Recommendation Report for Planning Permission for Works or Extension to a Dwelling

REF NO: BE/3/20/HH

LOCATION: 3 Central Avenue
Bersted
PO21 5HH

PROPOSAL: Two storey side extension.

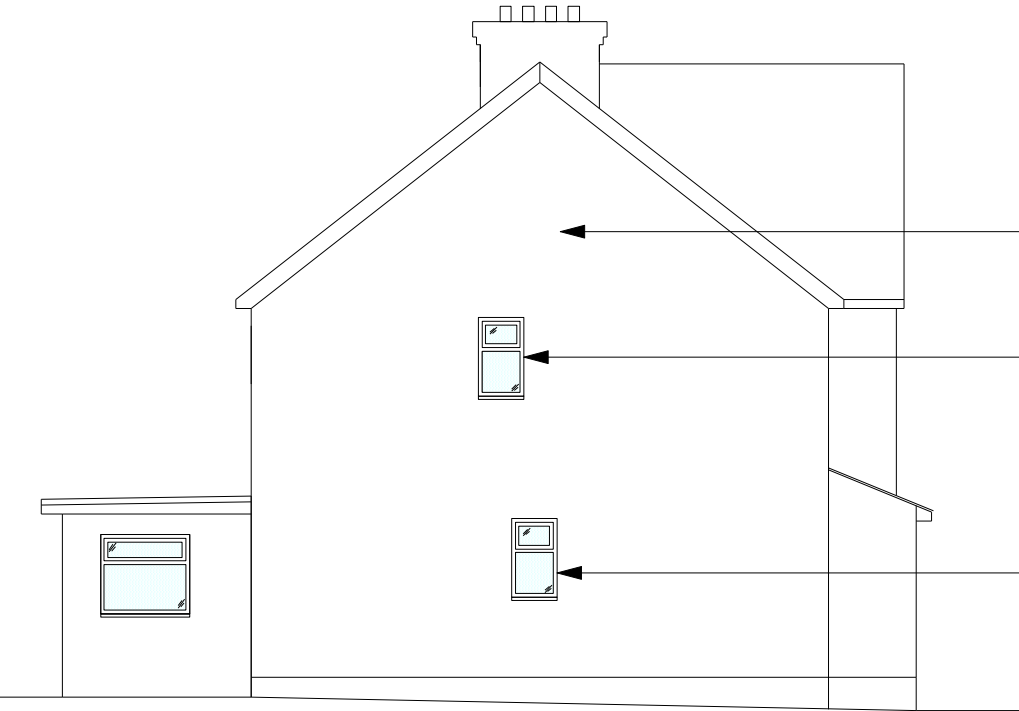
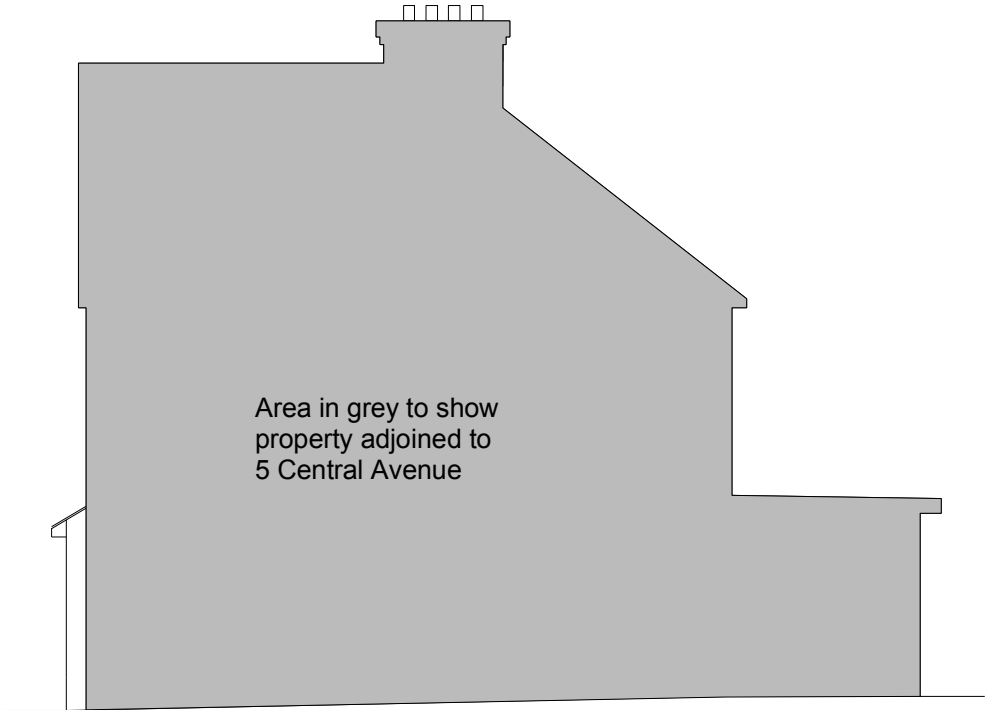
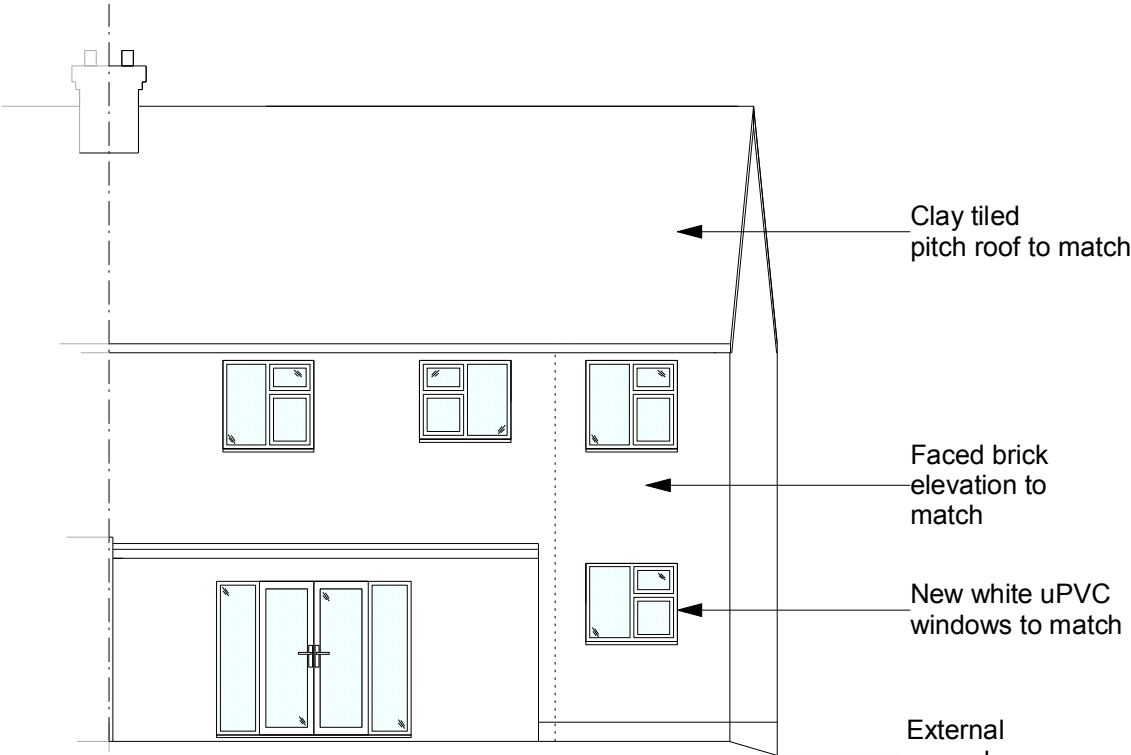
The proposal seeks to construct a two storey extension to the side of the property. The property is situated to a corner with a road running along the north and east elevation and with the extension situated to the east, it will be highly visible from the street scene.

The dwelling has a Mock Tudor painted timber design to the first floor and the extension incorporates this design to ensure the extension appears well integrated with the host dwelling.

The extension will meet with the ridge height of the host dwelling with the roof altering from a hipped to gable end. The surrounding area is mixed in appearance and the proposal is not considered to appear out of character with the area.

There will be an additional window to the first floor facing south however due to the siting and with sufficient distance retained to the rear, again it is not considered to result in adverse overlooking.

An additional window to the north and east will overlook the street scene.

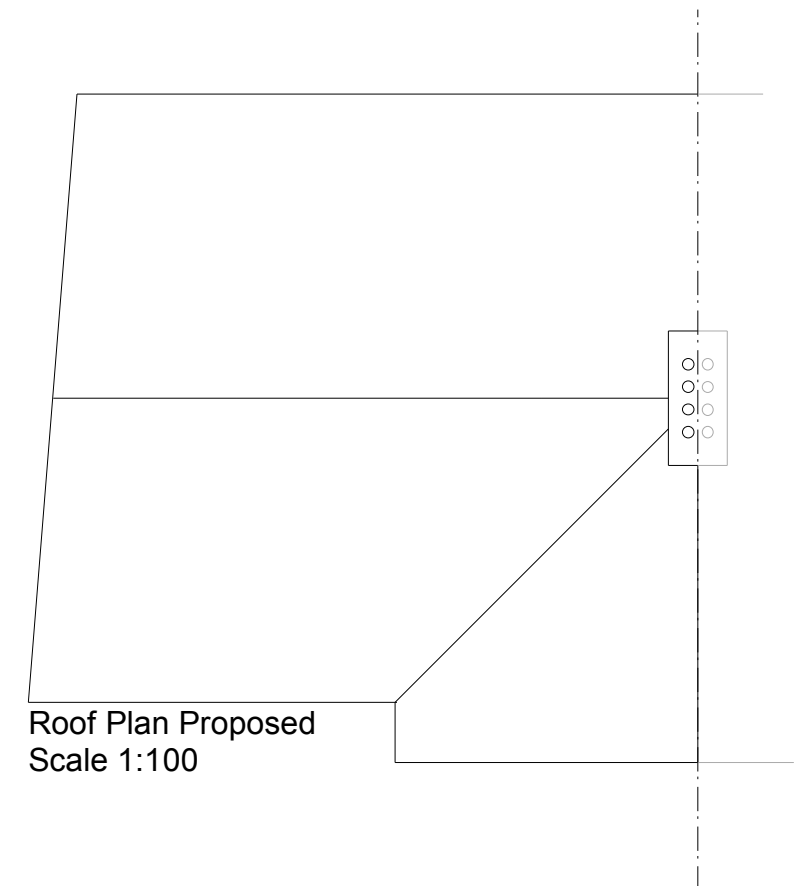
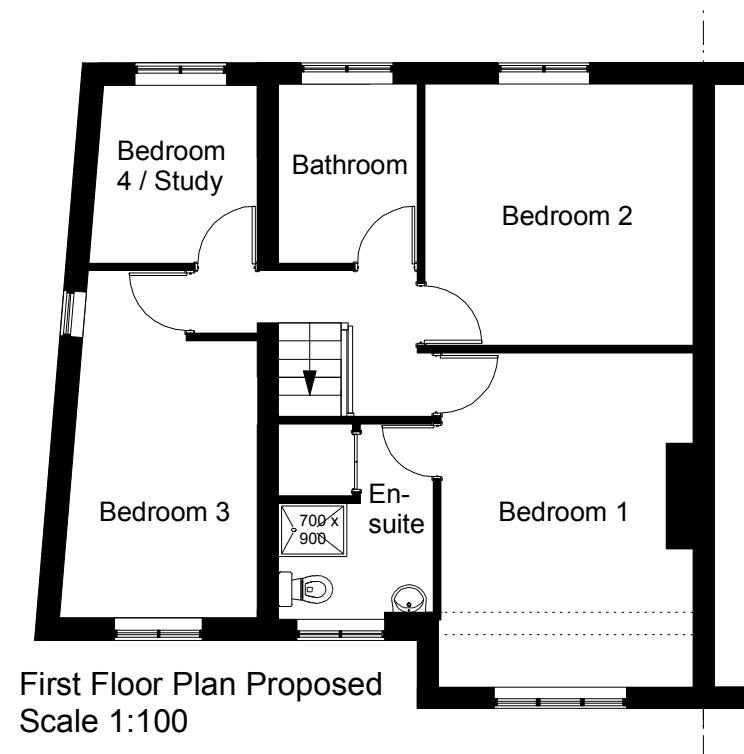
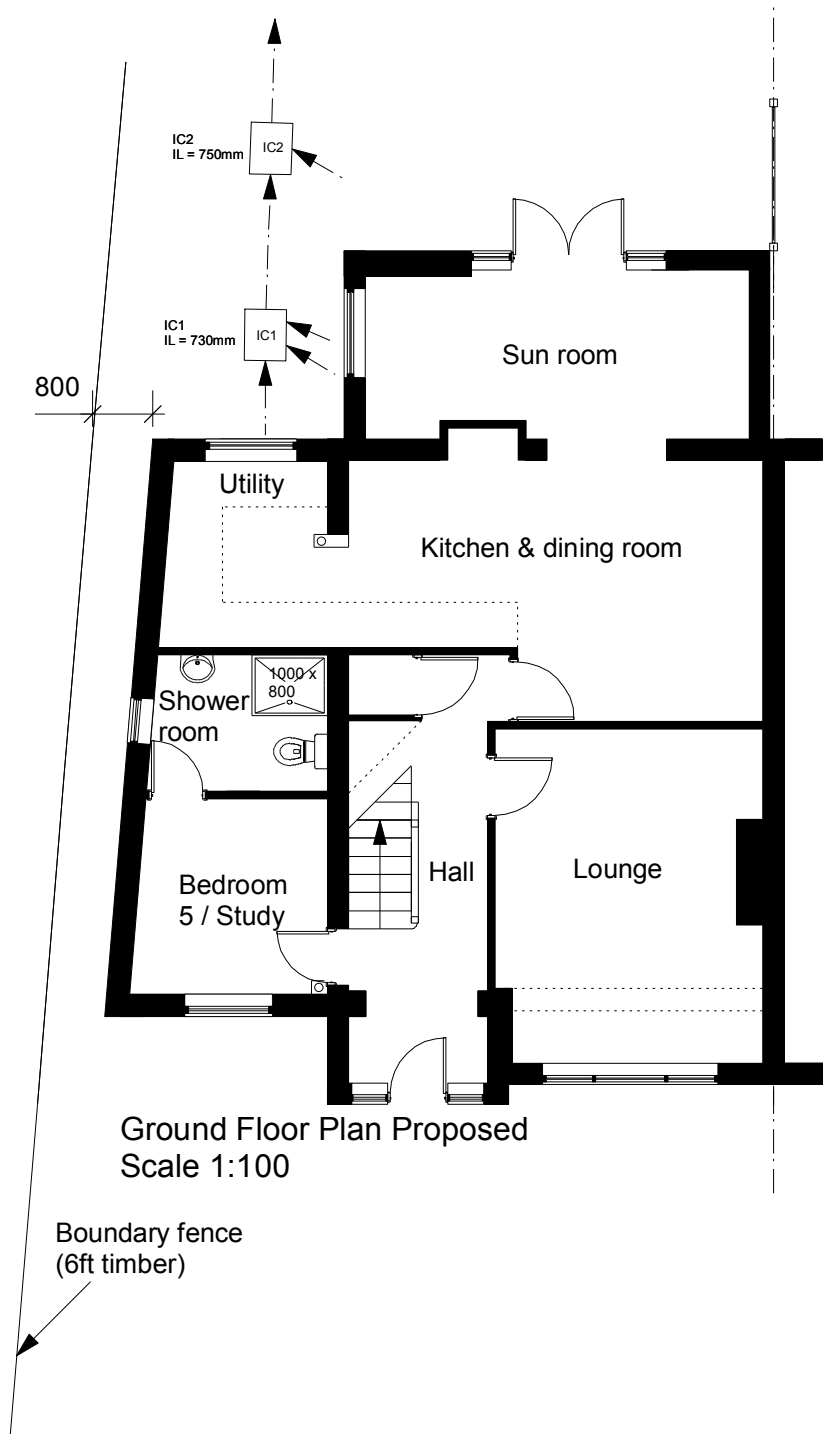
The extension is situated to the eastern elevation of the dwelling and will sit approximately 1m behind the principal elevation and retains 2.4m to the rear elevation. It will have a width of approximately 2.6m.
